Our Ref: FP/251/19/PL
Your Ref:

Development Altering of existing west access to site to allow for vehicular access for emergency & maintenance purposes only. Drop kerb formed to allow for vehicular crossover, area to include a new area of secure bin storage for the school.
fence off waiting area separating it from public access & existing vehicular entrance areas.

Location Bishop Tufnell C Of E Junior And Infant School Pennyfields Felpham

Thank you for the information you have sent following my previous letter. Unfortunately I am still unable to accept the application as valid until the following items are received or resolved:-

Drawing: EXISTING & PROPOSED PLANS

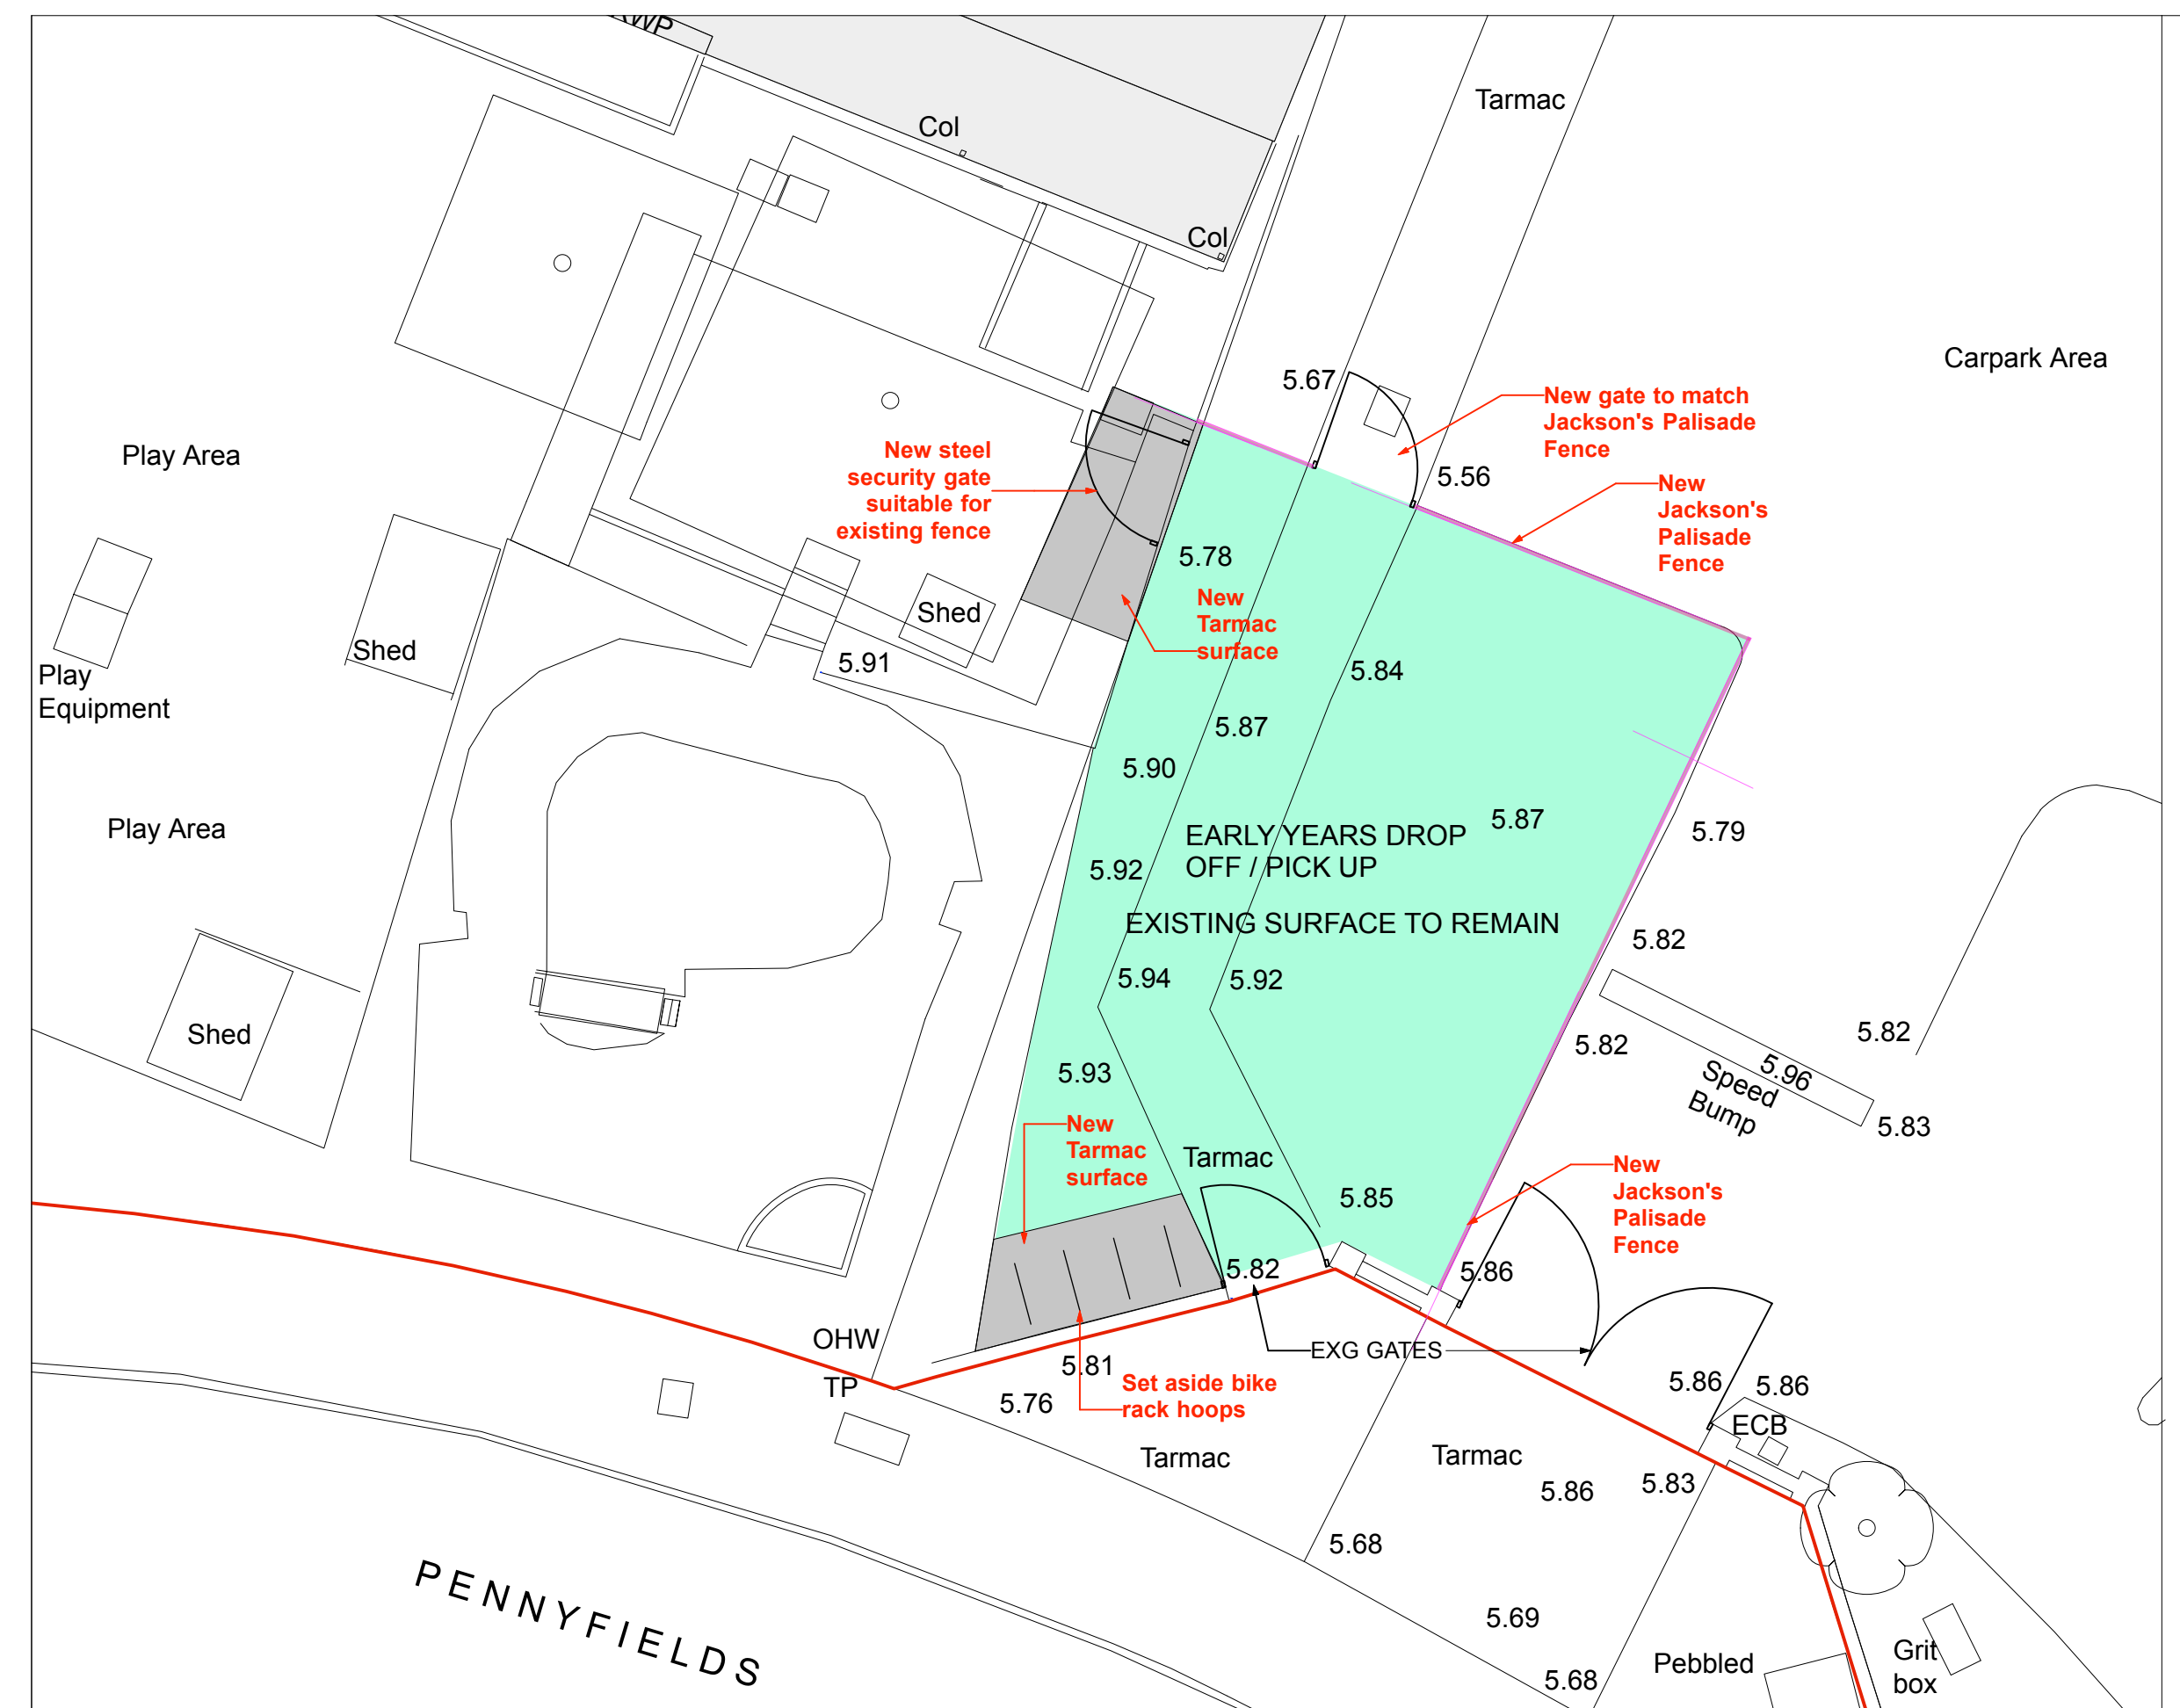
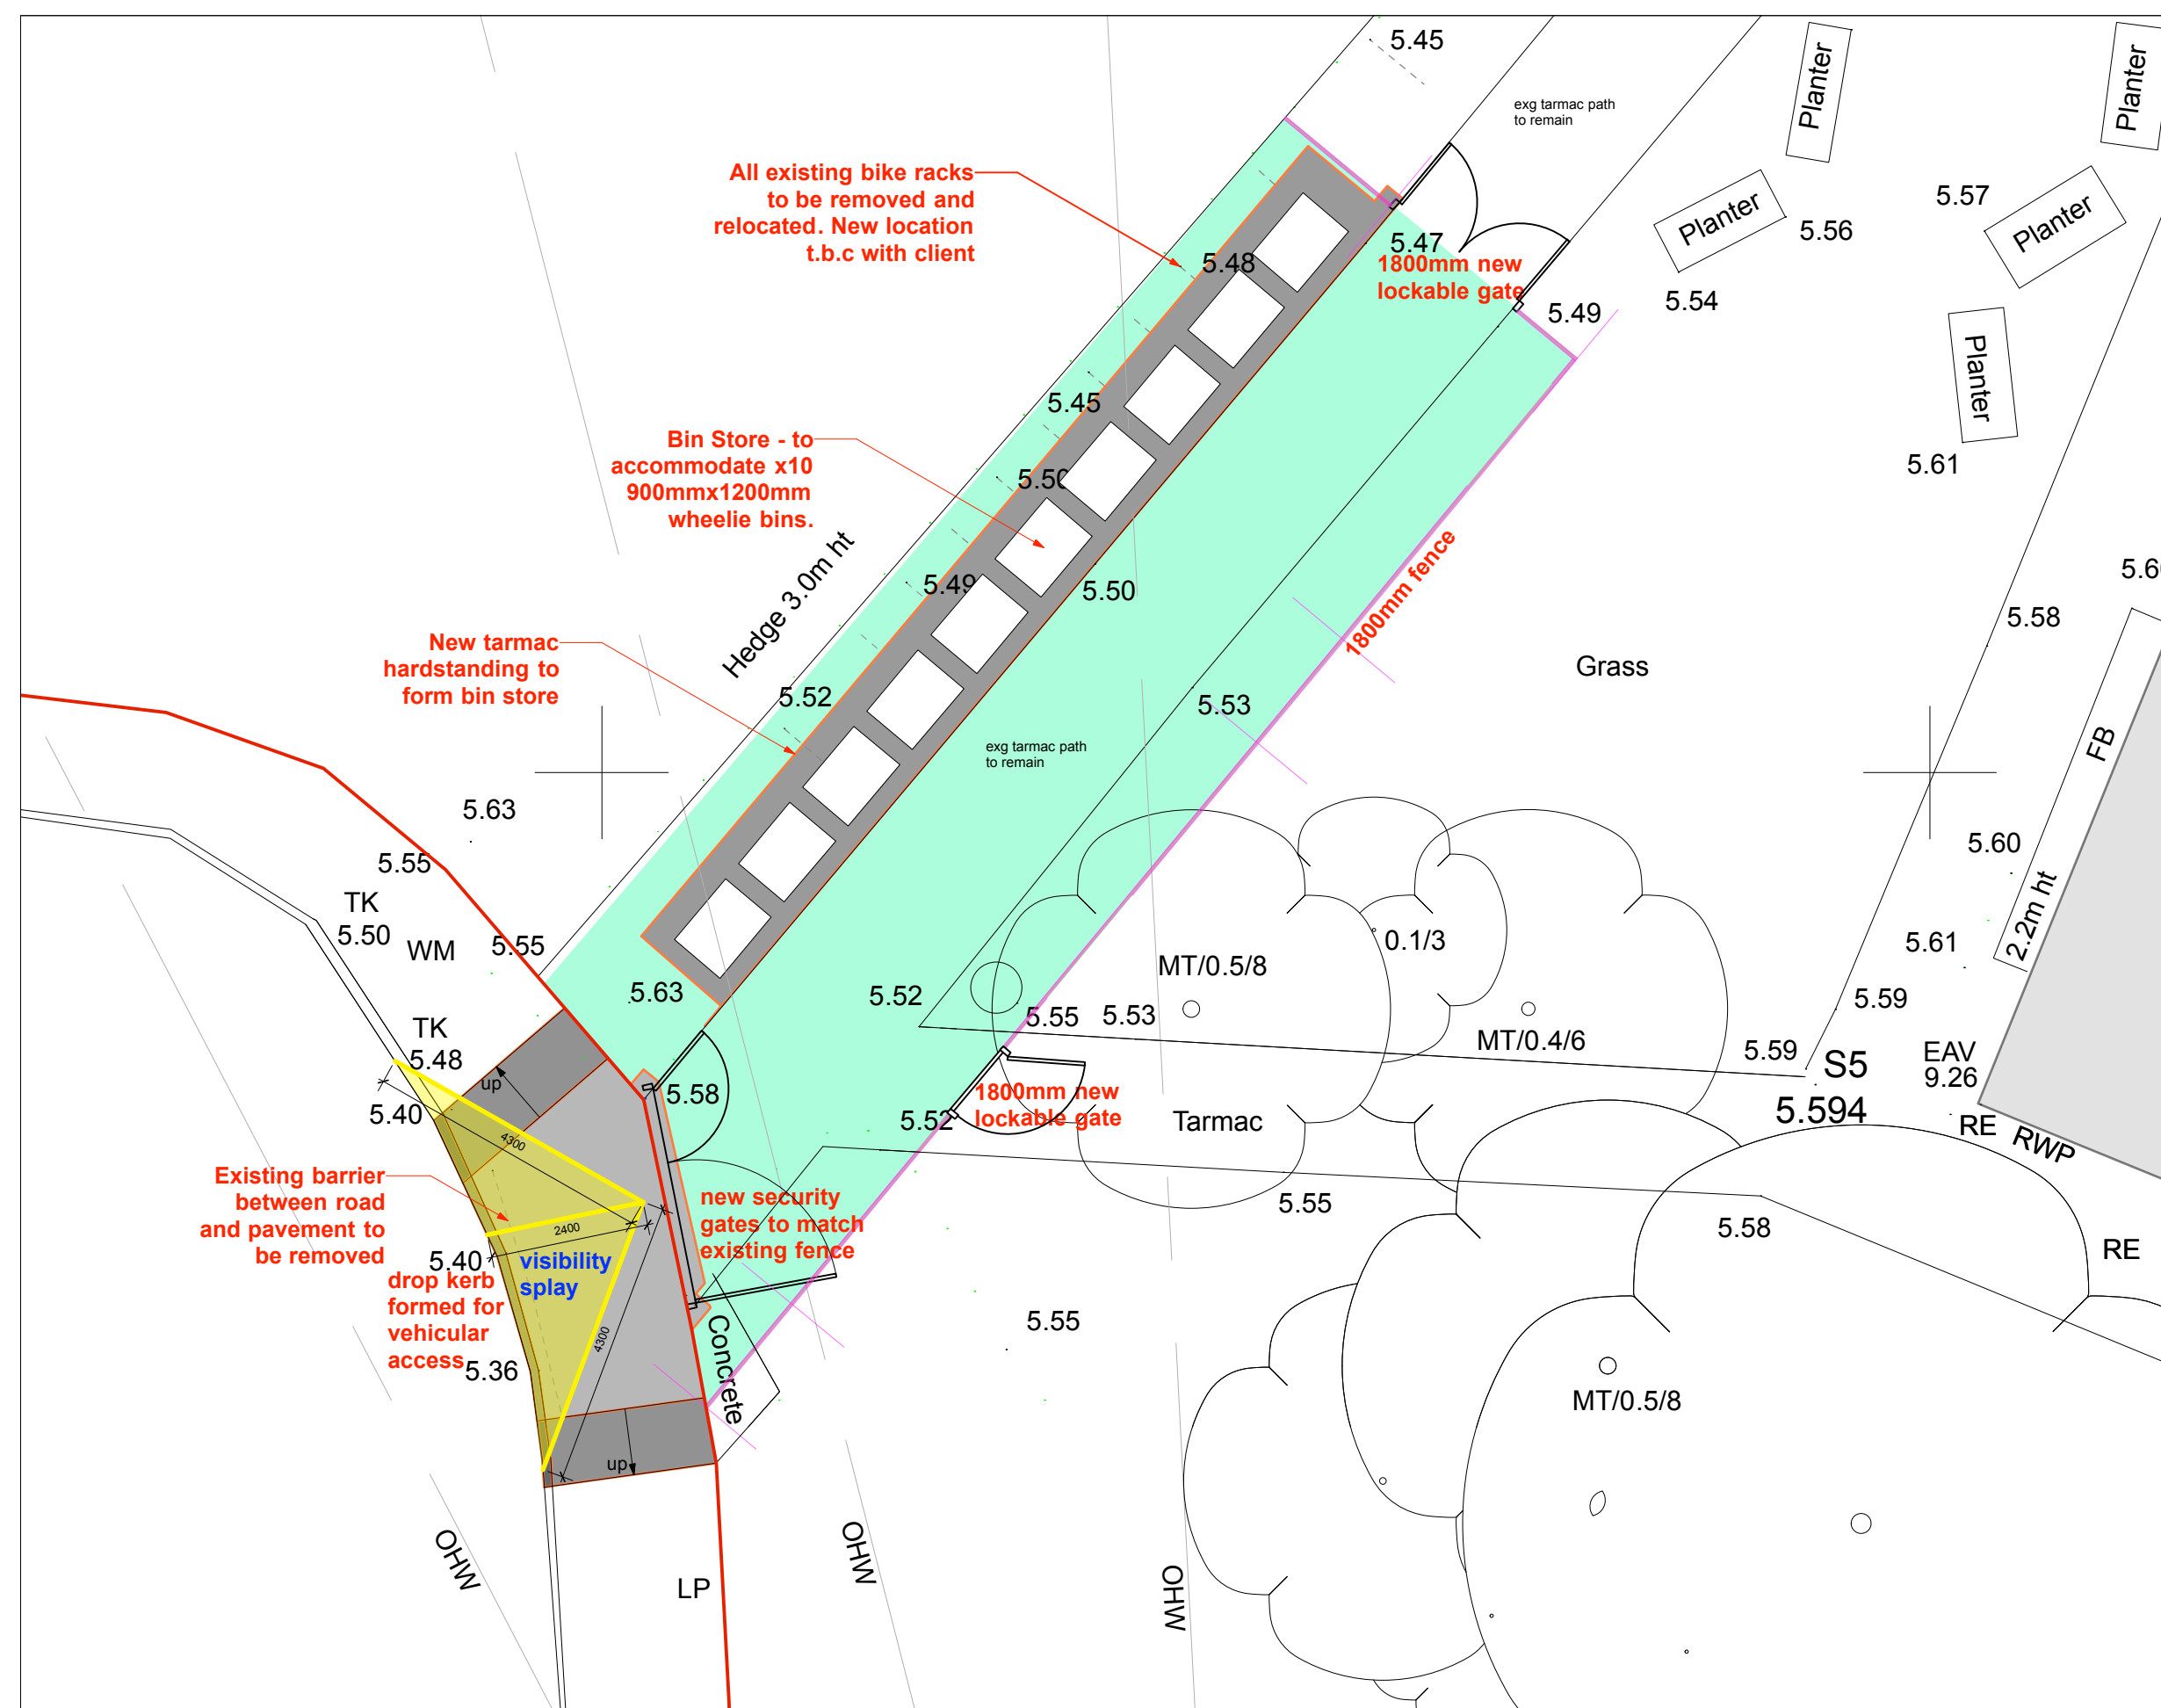
West Sussex County Council require that a visibility splay is provided. A splay is formed for a 30 mph speed limit road by measuring from a point 2.4m back from the kerb edge in the centre of the proposed access. A line should then be drawn from either side of this point for 43 m in each direction to the nearside edge of the carriage way. The splays must intersect land only within the control of the applicant, or within the publicly maintained highway.

The distance will increase with the speed limit of the road. If the road is 40 mph speed limit then the distance should be 120 m either side. For speeds above this please contact West Sussex County Council Highways for advice on what would be acceptable.
